**KIRKLEES METROPOLITAN COUNCIL
INVESTMENT & REGENERATION SERVICE**

**DELEGATED DECISION TO DETERMINE APPLICATIONS FOR
CONSENT, AGREEMENT OR APPROVAL REQUIRED BY CONDITION**

Reference No:	2023/44/91200/E
Site Address:	Land off, Briestfield Road, Briestfield, Dewsbury, WF12 0NR
Description:	Discharge conditions 5, 6, 7 on previous permission 2021/93111 (APP/Z4718/W/22/3300539) for erection of agricultural building
Recommending Officer:	Nicole Helliwell

Officer Report

title access & internal service area details
number 21099D-05-P01
scale 1:200
size A3

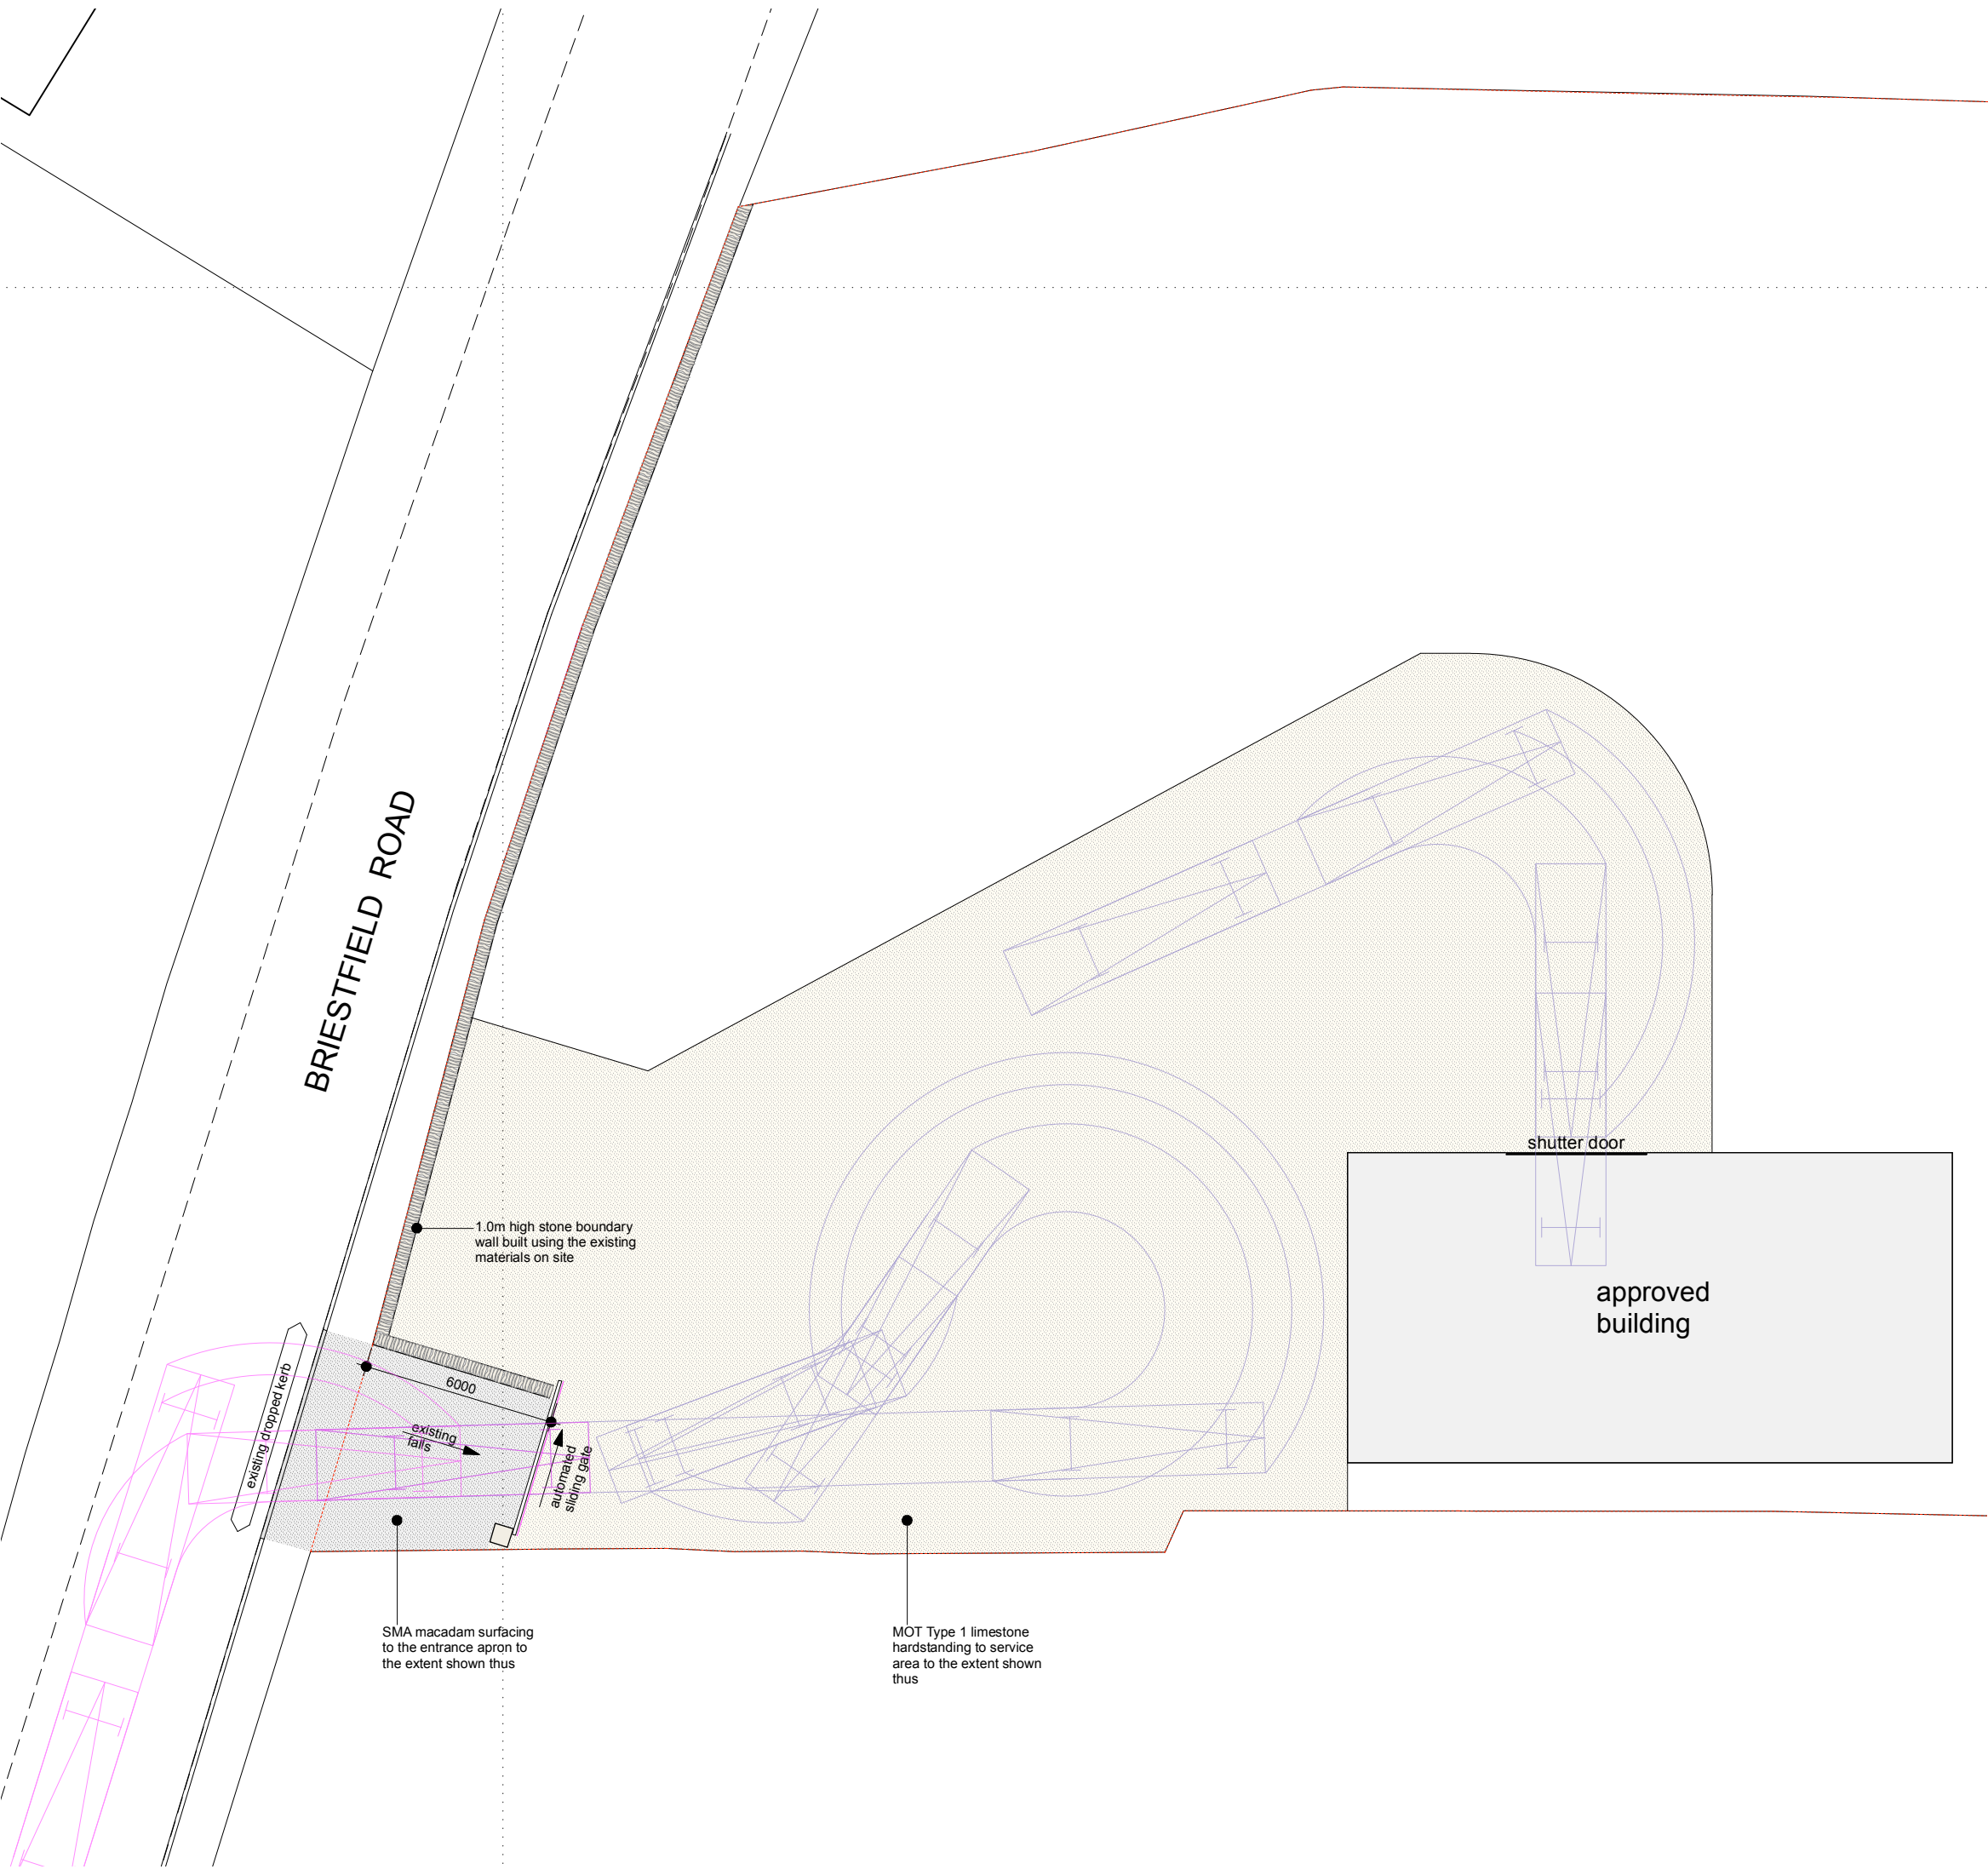
The applicant has submitted Access and Internal Service Area Details (21099D-05-P01, 18th April 2023) and Access & Internal Service Area Details 2 (21099D-06-P01, 26th June 2023) with the discharge of condition application. KC Highways Development Management have commented on this information in relation to condition 5.

The first plan shows the turning movements of an HGV within the site and the second an agricultural tractor. However, the applicants have confirmed in an email dated 27th June that the largest vehicle that will regularly visit the site will be a tractor. The plan demonstrates that the tractor will have sufficient space to stand in front of the existing gates without obstructing the highway. Furthermore, the plans confirm that the first 6m of the access will be surfaced in tarmac and that the boundary wall will have a height of 1.0m to assist visibility onto Briestfield Road. Public right of way DEW/79/40 is also displayed on the plans. KC Highways are satisfied with the submitted information and therefore Condition 5 will be discharged by the implementation of the approved details prior to first occupation, and their retention thereafter.

In conclusion, it is considered that the submitted details are acceptable for the purposes of condition 5. However, Condition 5 will be discharged by the implementation of the approved details prior to first occupation, and their retention thereafter.
